**Consultation Response from KC,
Highways Development Management****2024/90769 adj, 27, Riley Park, Kirkburton, Huddersfield, HD8 0SA****Erection of one detached dwelling and associated works****Date Responded: 5-6-2024.****Responding Officer: Mark Berry.****Responding Ref: 12-42-2.**

Site Plan

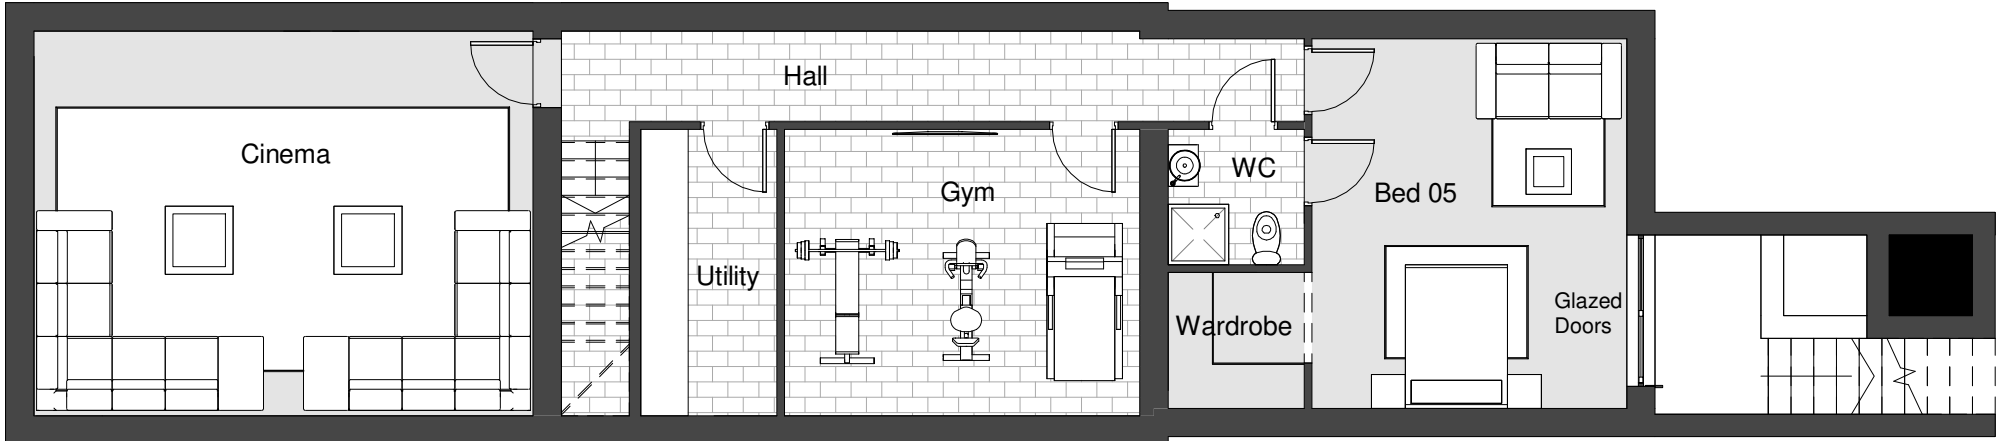
1, No driveway gradient is specified. This needs to be specified, the maximum acceptable gradient is 1 in 8.

2, No bin collection point is shown on the plans. A bin collection point should be shown to be provided to enable bins to be presented on collection day without either obstructing the highway or proposed driveway.
